15/12/2020

**Baal Bone Coal (09\_0178)  
Proposed Changes to Groundwater Monitoring Program**

Chart 2 Dissolved zinc concentrations measured at BBP3 and cumulative rainfall deficit at Lithgow (Birdwood St)

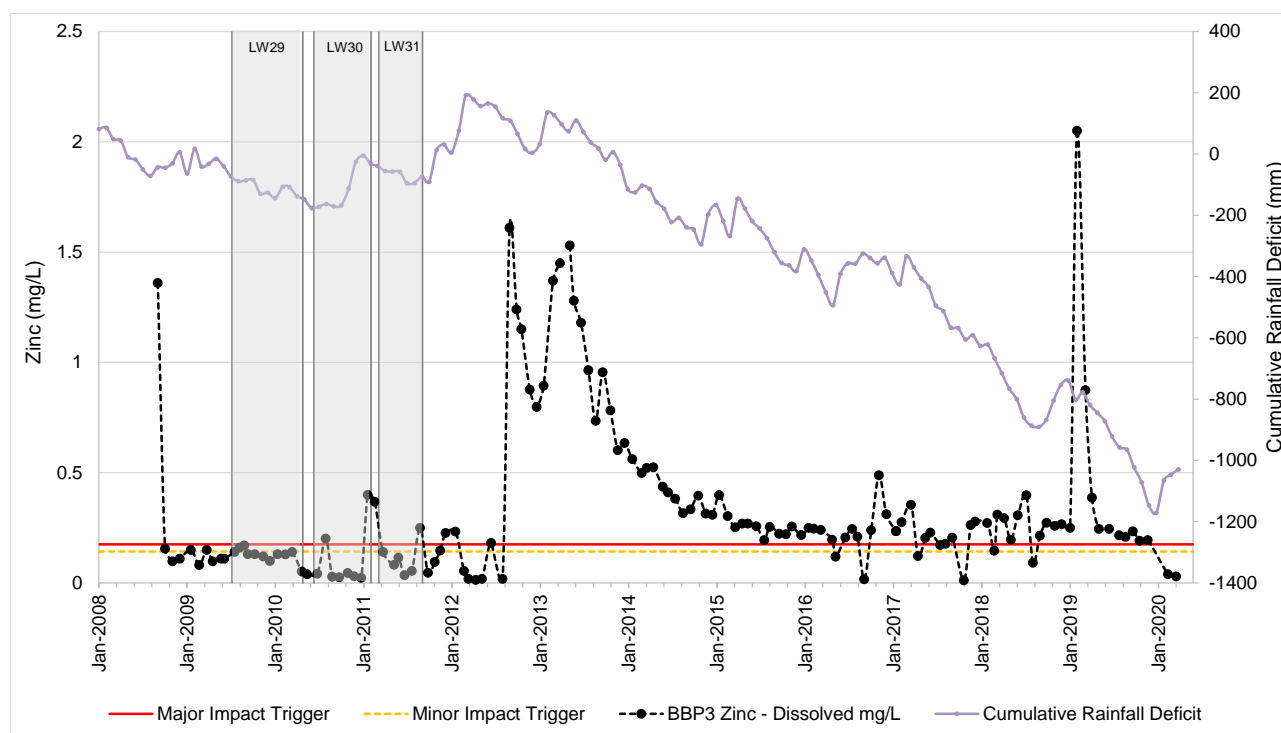
The Department notes that elevated zinc concentrations at BBP3 have been frequent since the completion of mining and therefore questions the option to reduce frequency during the remaining stages of mine closure.

To determine the appropriate monitoring program for Cocks River Swamp, the Department requests that a revised monitoring program is submitted within an amendment to the site's Water Management Plan, following consultation with DPIE Water, particularly in relation to future monitoring requirements at BBP3.

Chart 6 Dissolved zinc measured at BBP1-BBP6 with (major and minor change criteria for zinc)

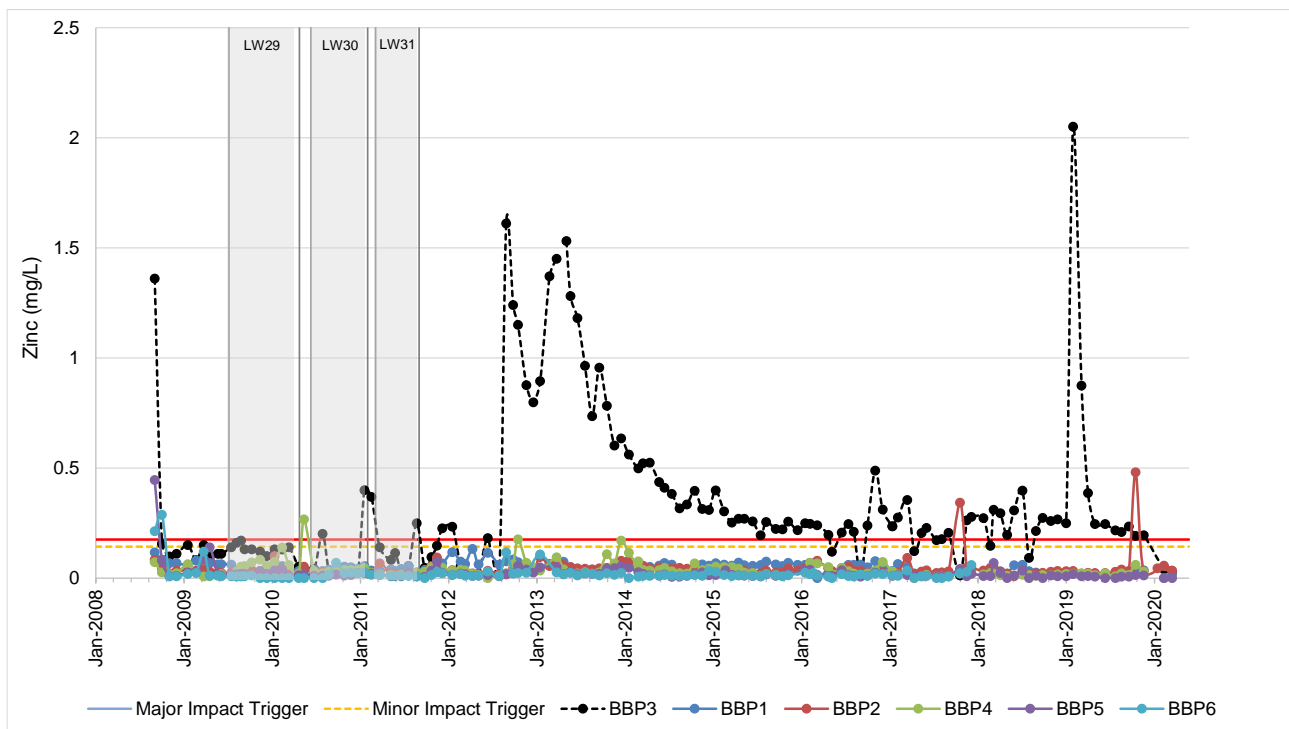
The Department does not disagree in principle to reducing the frequency of monitoring at locations where data indicates that water-related mining impacts have stabilised. However, it is considered that ceasing monitoring at the proposed sites (ie BBP1, BBP2, BBP5 and BBP6) altogether may be premature given sporadic triggers of elevated zinc concentrations over time and the uncertainty associated with the contribution of mining to these impacts. On this basis, the Department considers that monitoring at these sites should continue on at least a quarterly basis.
